## Submission Form

**Epping to Thornleigh Third Track Proposal.** Application number SSI 5132.

Figure 5.6 Cross-section and elevation - New Cheltenham Station concourse building
Note: Indicatively added to future design

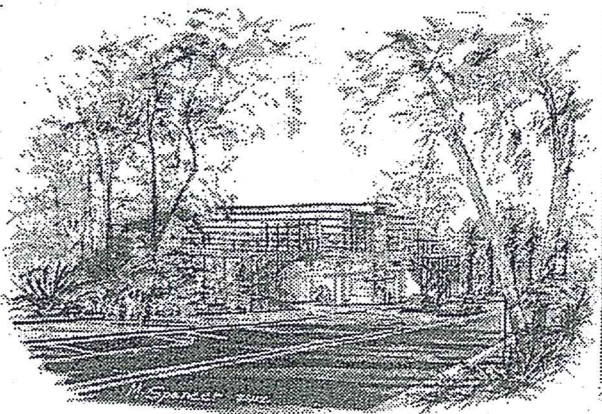
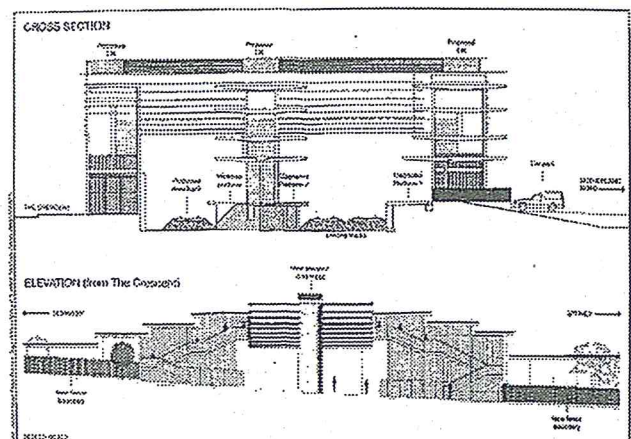
- The proposed redevelopment of Cheltenham Station shows no regard for the HCA. The visual impact of the proposed 13m high glass and steel concourse is totally unacceptable in this HCA.
